Bowland with Leagram Parish Council

Re Planning Application No. 3/2012/0432

Proposed 2no. proposed detached garages with associated external works.

Pale Farm Cottages, Moss Lane, Chipping, PR3 2TR

SITE PLAN 1:500

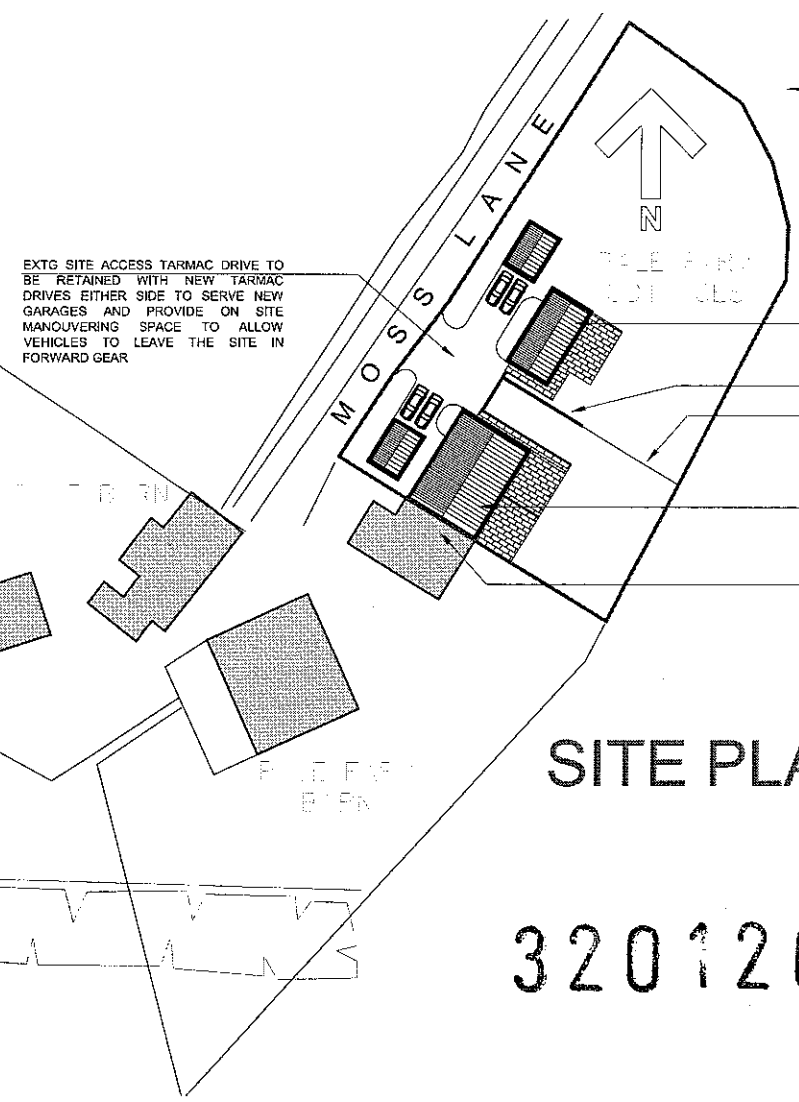
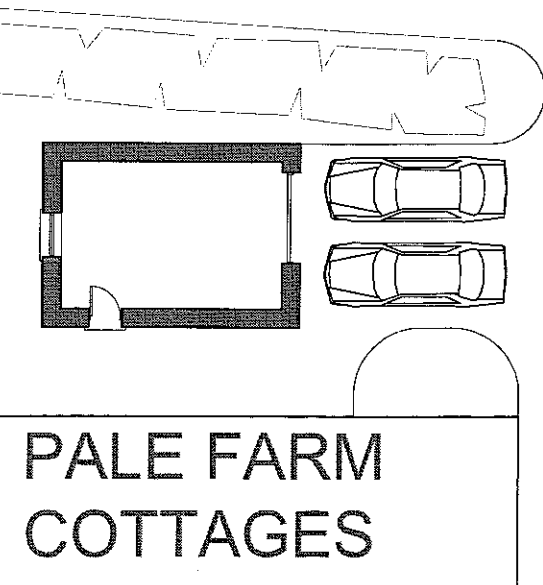
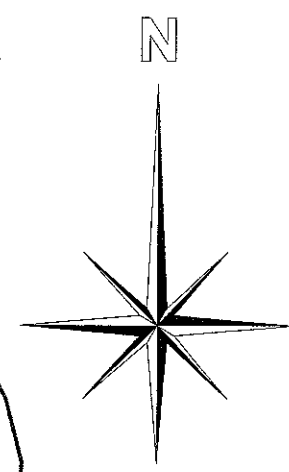
- 1) The two detached garages will obscure the view of the Lane for some residents and may reduce the light to some properties. It was felt that repositioning the garages to the South Side would not be as invasive to others and would be recommended and supported.
- 2) The new stone dividing wall will reduce the space which is currently used as a turning point for large vehicles such as refuse collection, fuel oil and coal delivery vehicles, and emergency services. This may result in difficulties and inconvenience for other residents should large vehicles be unable to manoeuvre.
